Re: Observation on case reference VA20.321238

'Planning application for a 110 kilovolt electricity substation, approximately 7.5 kilometres of underground electricity line and all associated works at Moyvannan, Feamore, Lisbaun, Carrownolan, Carrowncloghan, Carrowkeeney, Ardmullan, Curraghboy, Gortnasythe, Derryglad, Eskerbaun, and Brideswell, County Roscommon.'

Observation on case reference VA20.321238

Drawing Title: **FIGURE 12: JOINT BAY SPECIFICATION**

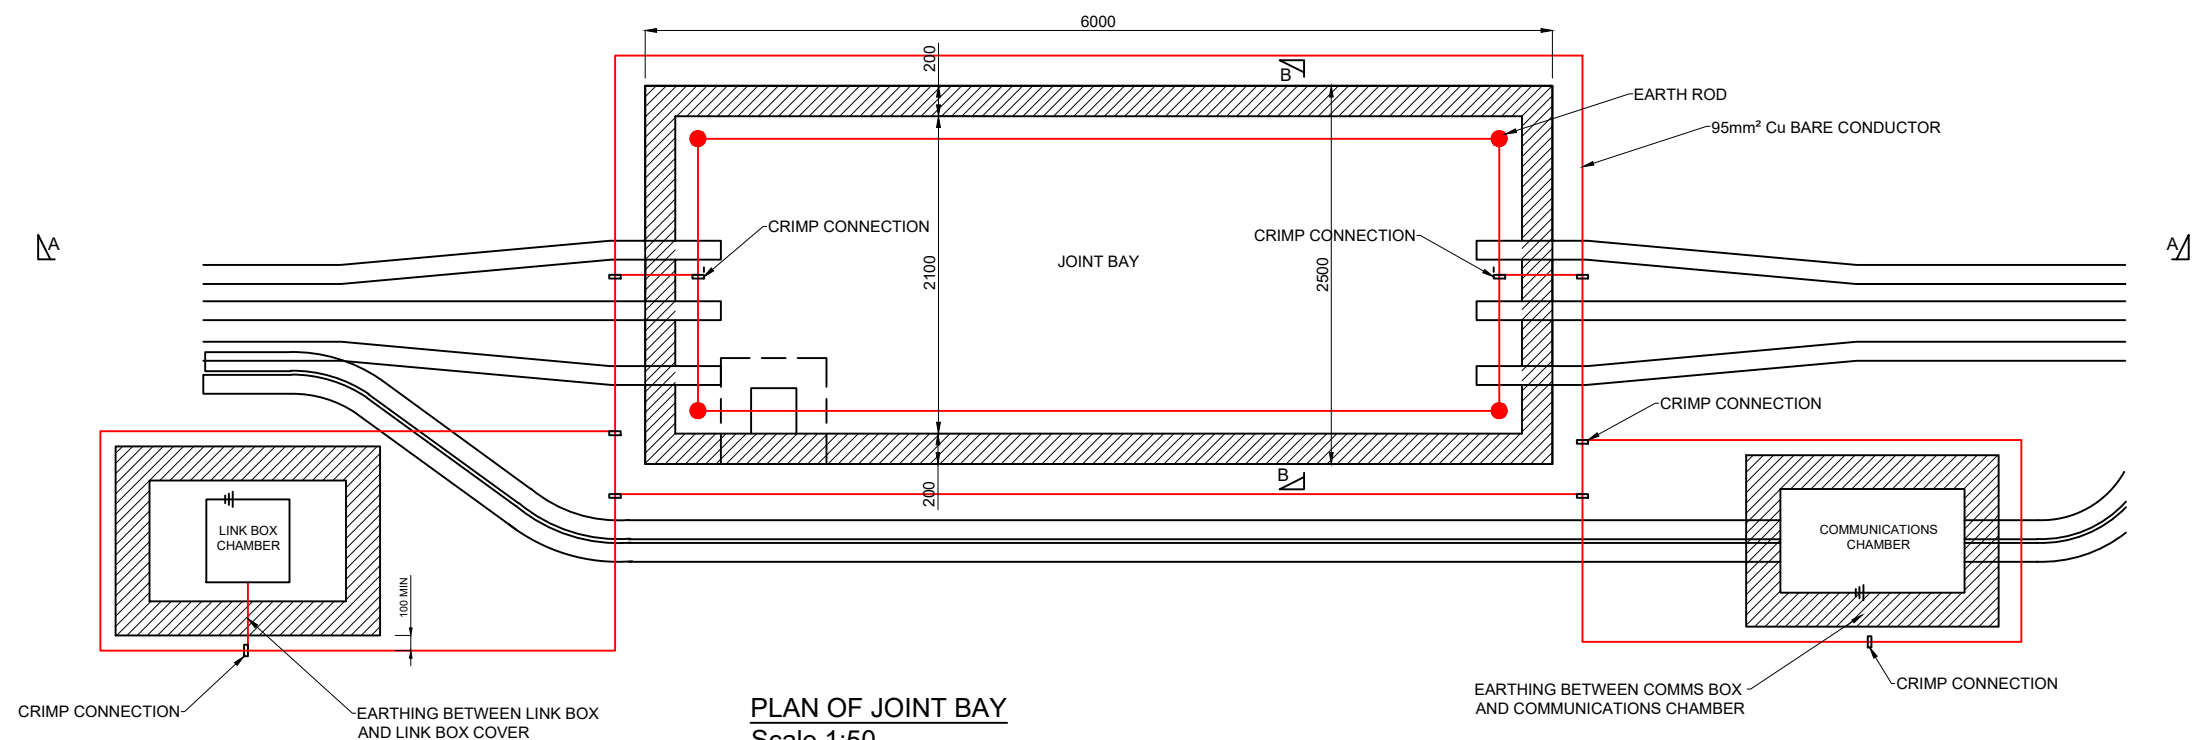
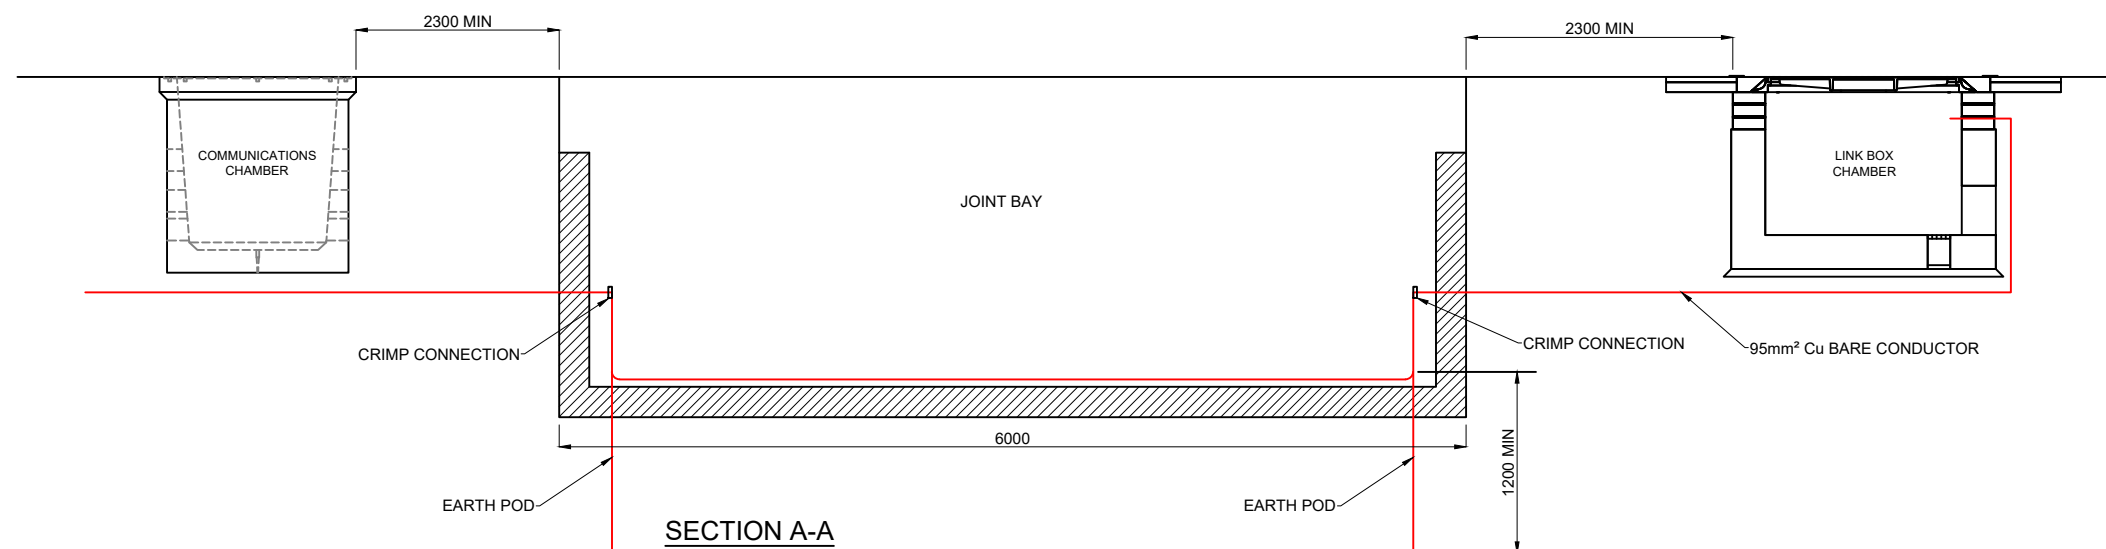
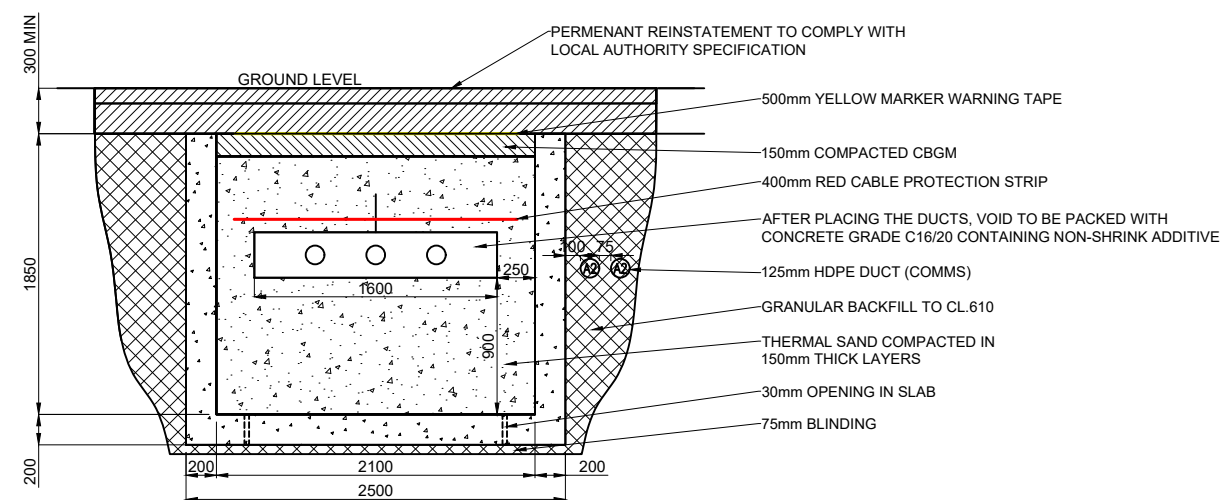
- Energia plan to install joint bays within roadside verges. On the map joint bays are shown in blue and are located every 600/700 metres along the road. However, the local roads are not wide enough to accomodate the joint bays. Width of roads can be as narrow as 3.0 metres. Joint bays are approx. 4.0 metres wide. How are these joint bays going to be accommodated?
- We are requesting an oral hearing in this case.
